**Baxter Academy Interior Fit-up - Response to Review  
Comments**

185 Lancaster Street, Portland, Maine

Drawing file: Plans / 11. A2 BUILDING ELEVATIONS.pdf

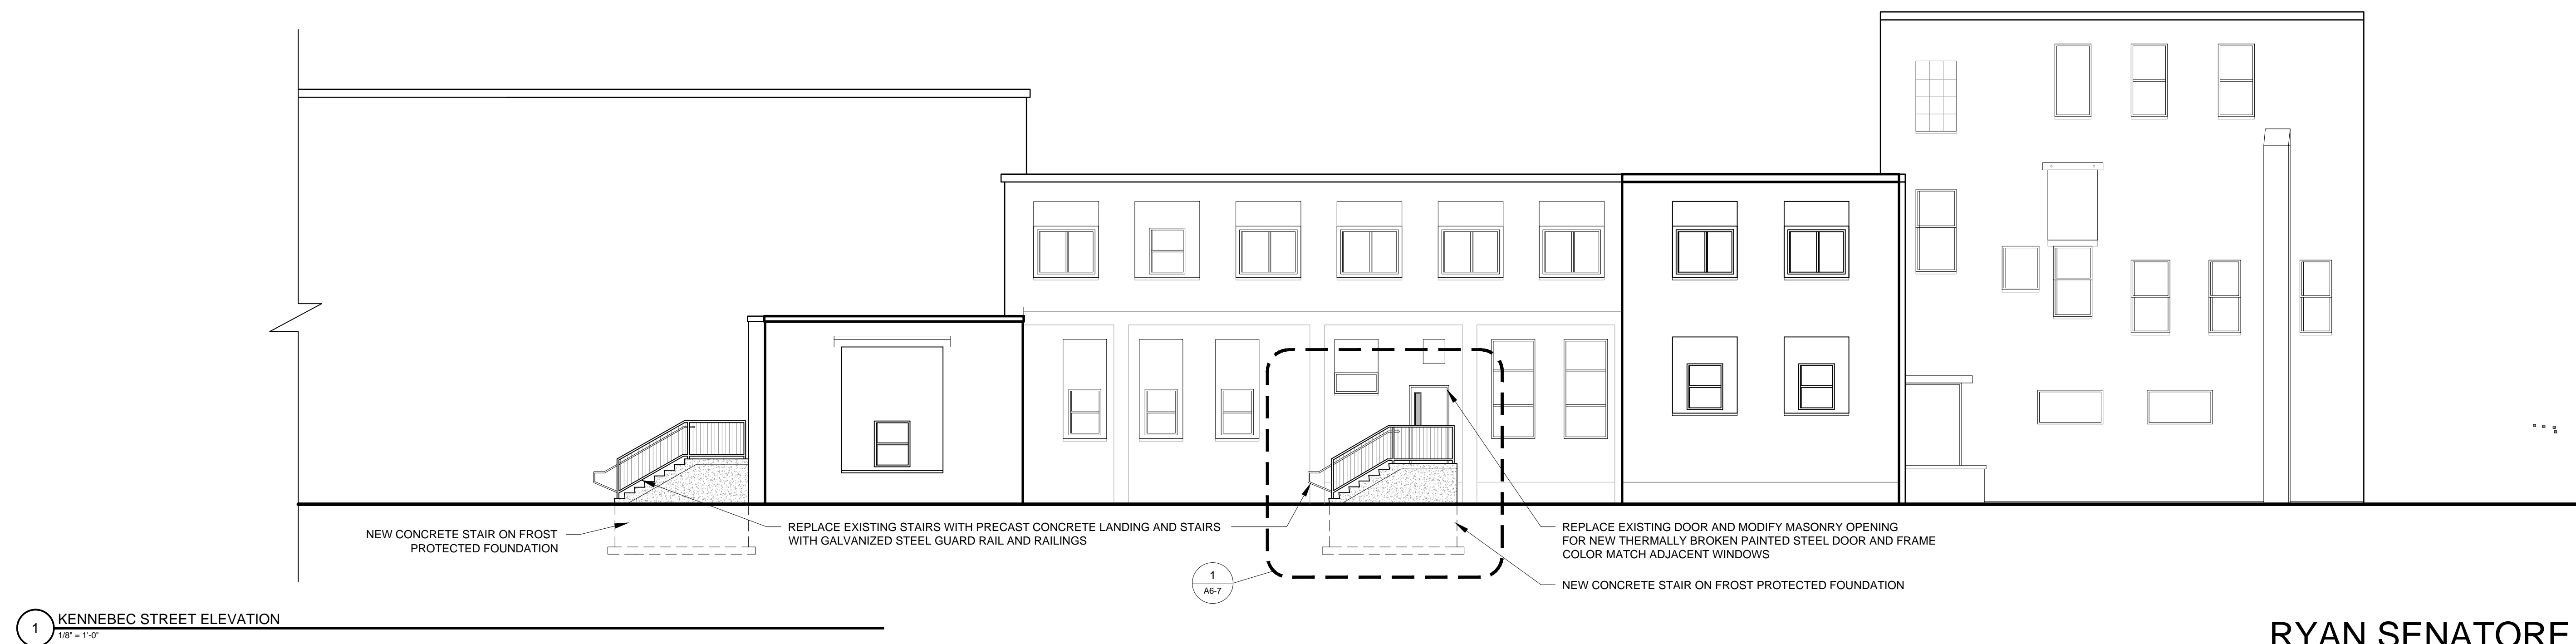
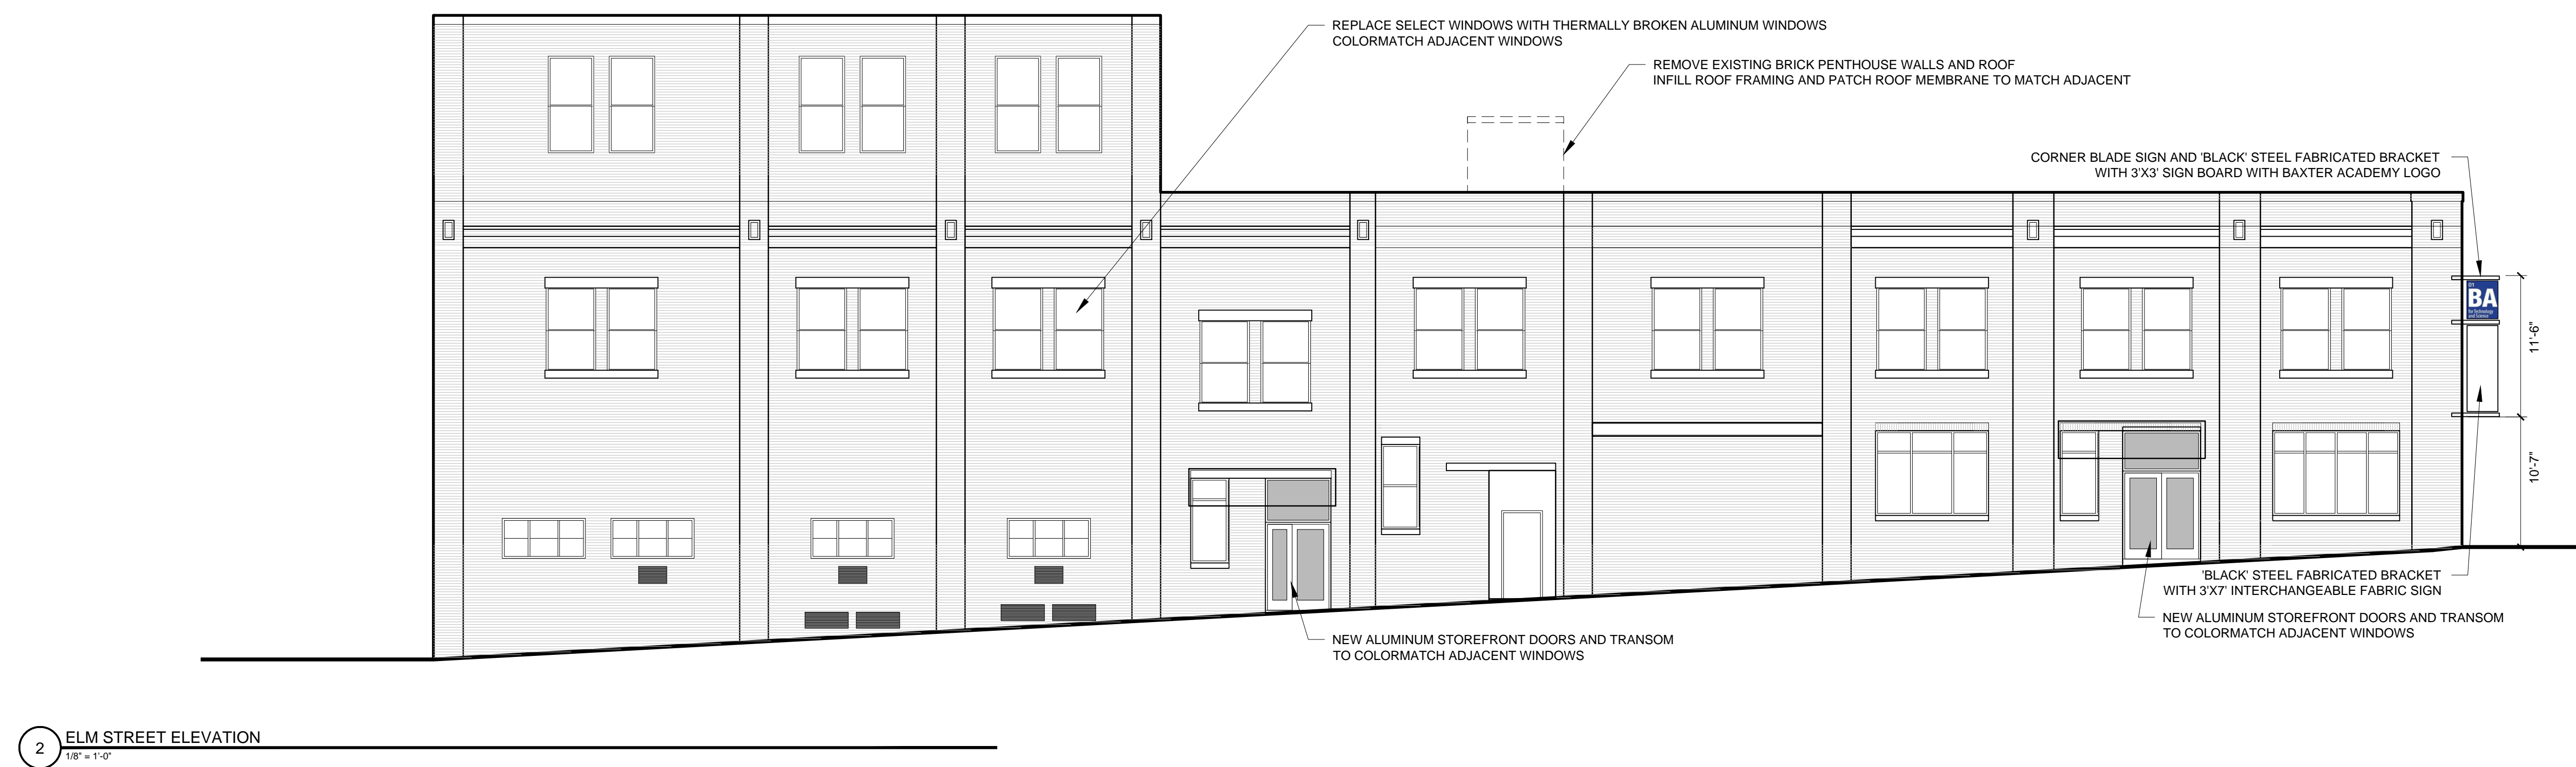
A.8) The proposed exterior signage is shown on the exterior elevations submitted to the City, they are not lit signs. The signs are placed on the facades to help the users of the building navigate to the main entry on

Drawing file: Plans / 5. Grading Plan.pdf

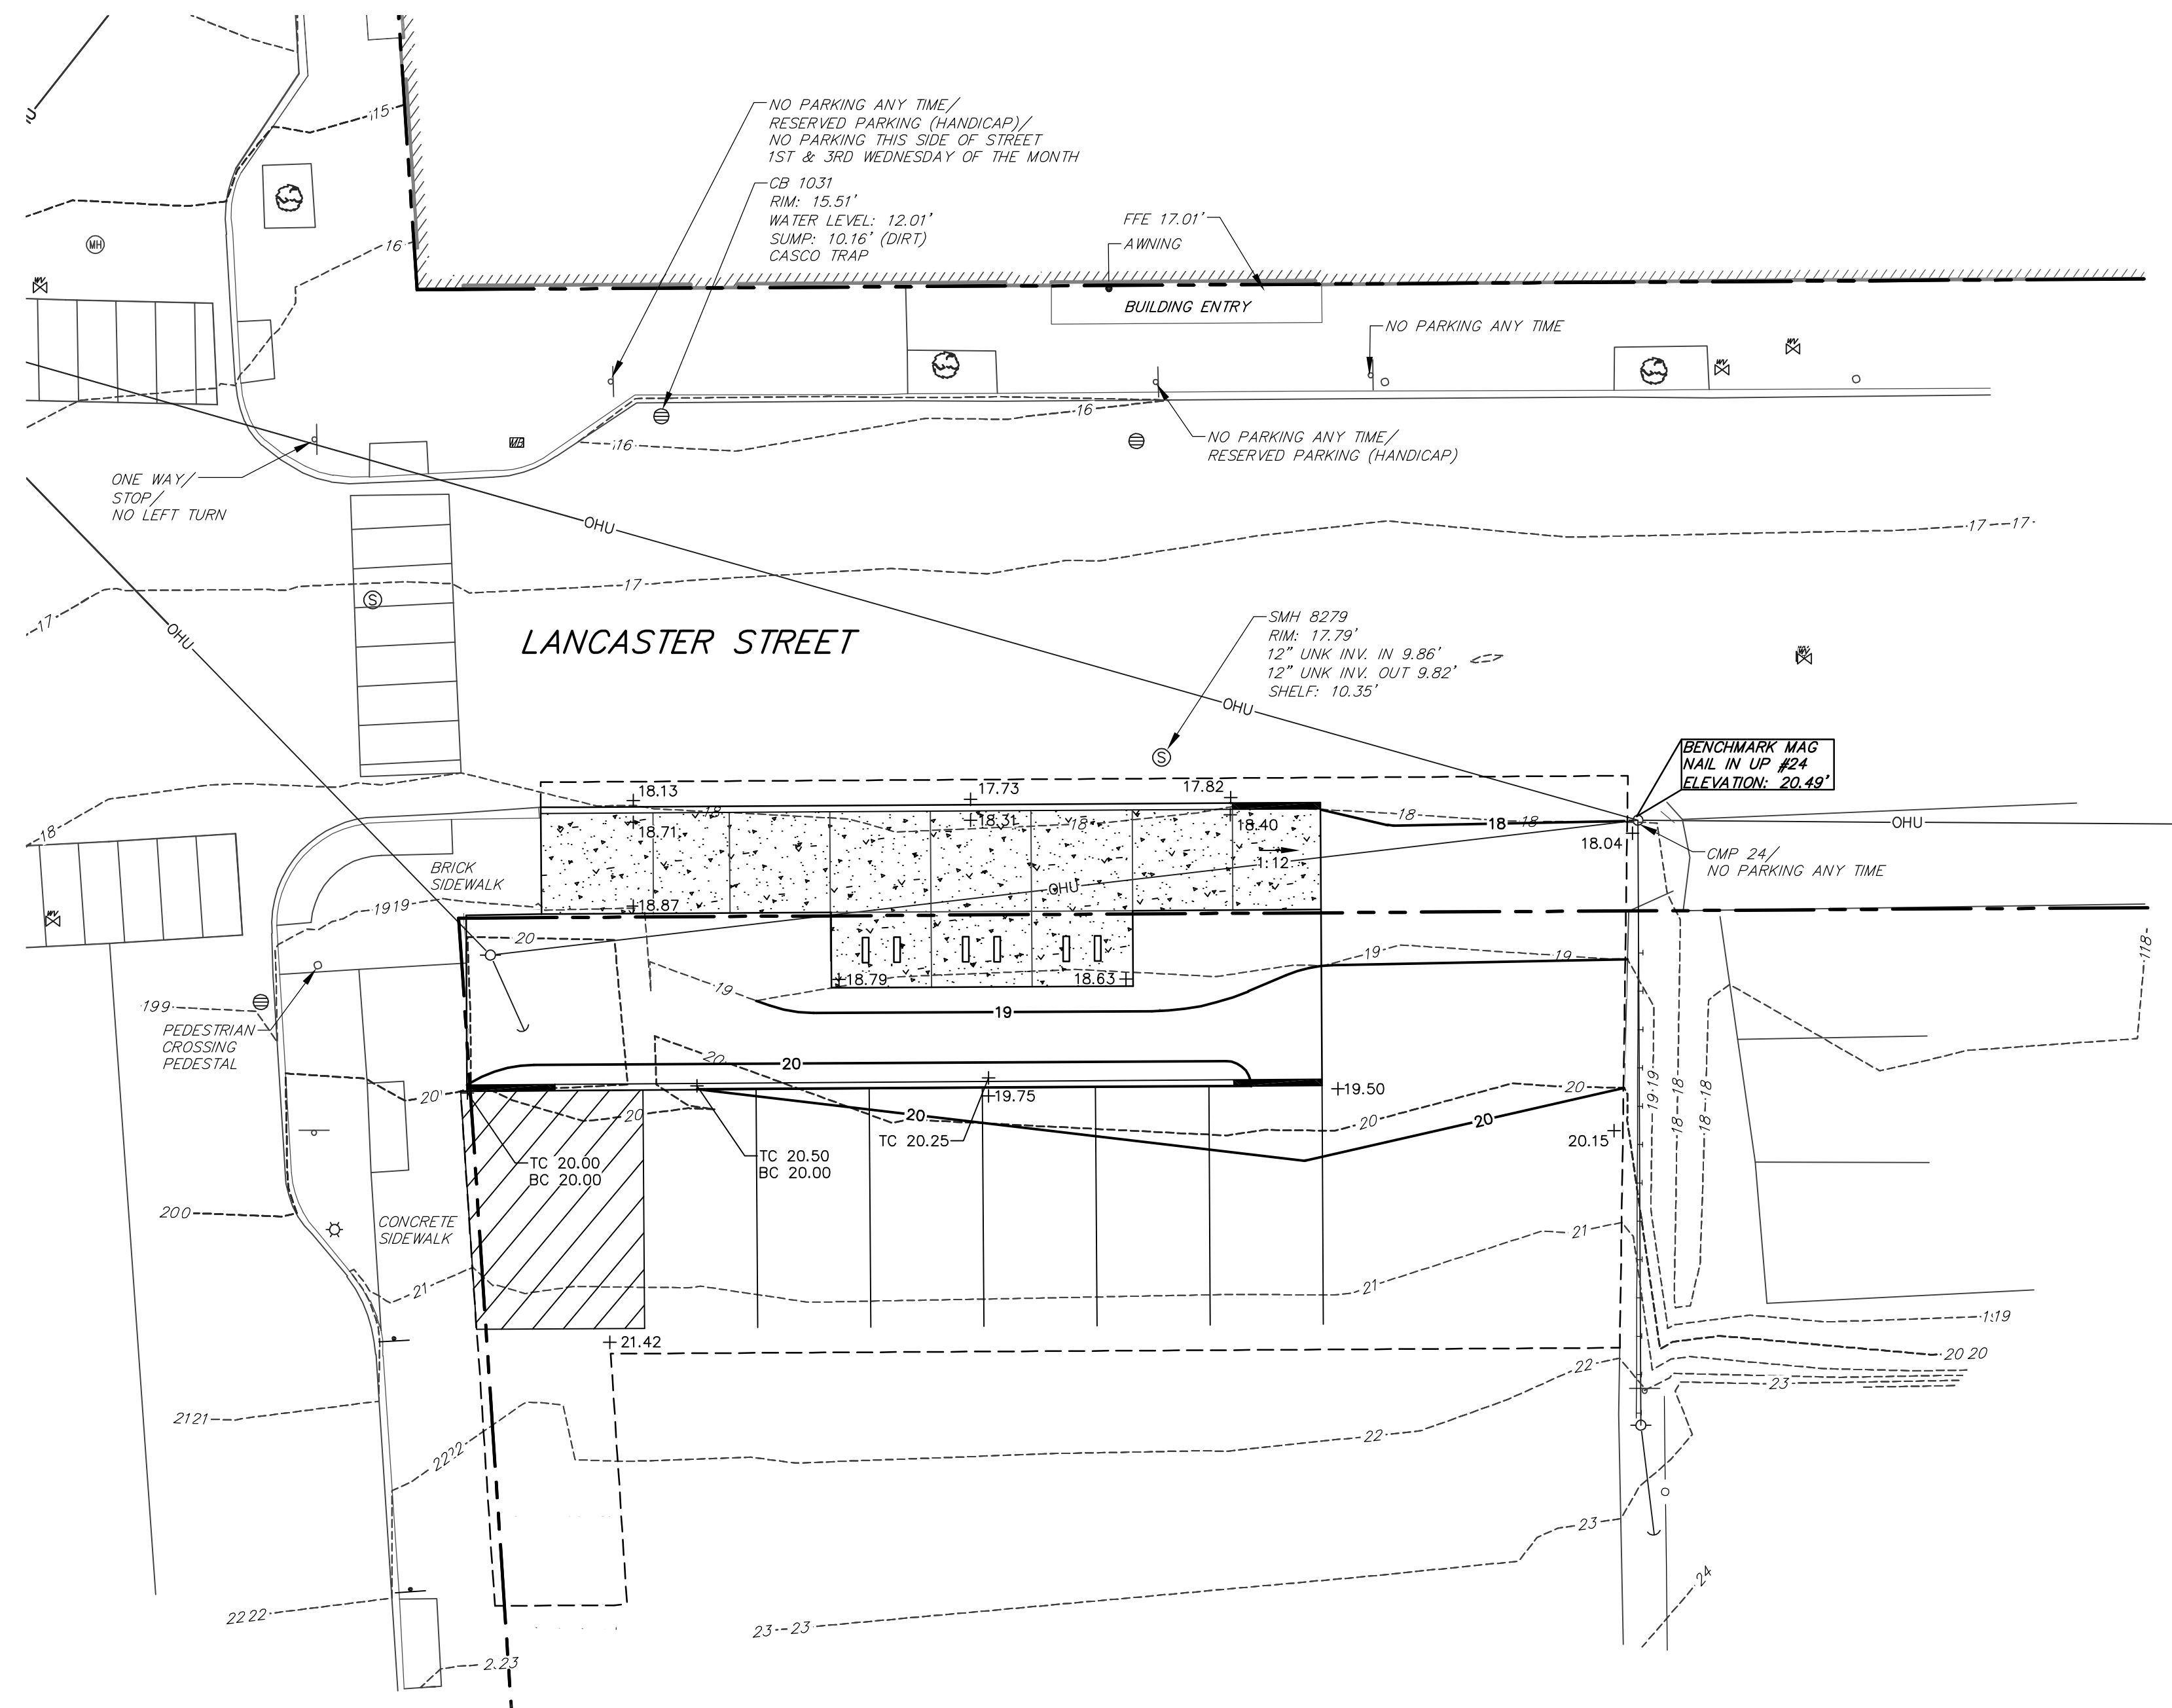
B.2) The Survey plan shows the right of way 3.1' from the outer building edge to the property line, the proposed stairs are flush with the building bump out edges. Please see the attached excavation plan from Landry French with requires 12" of over excavation so the excavation will be within the property boundaries.
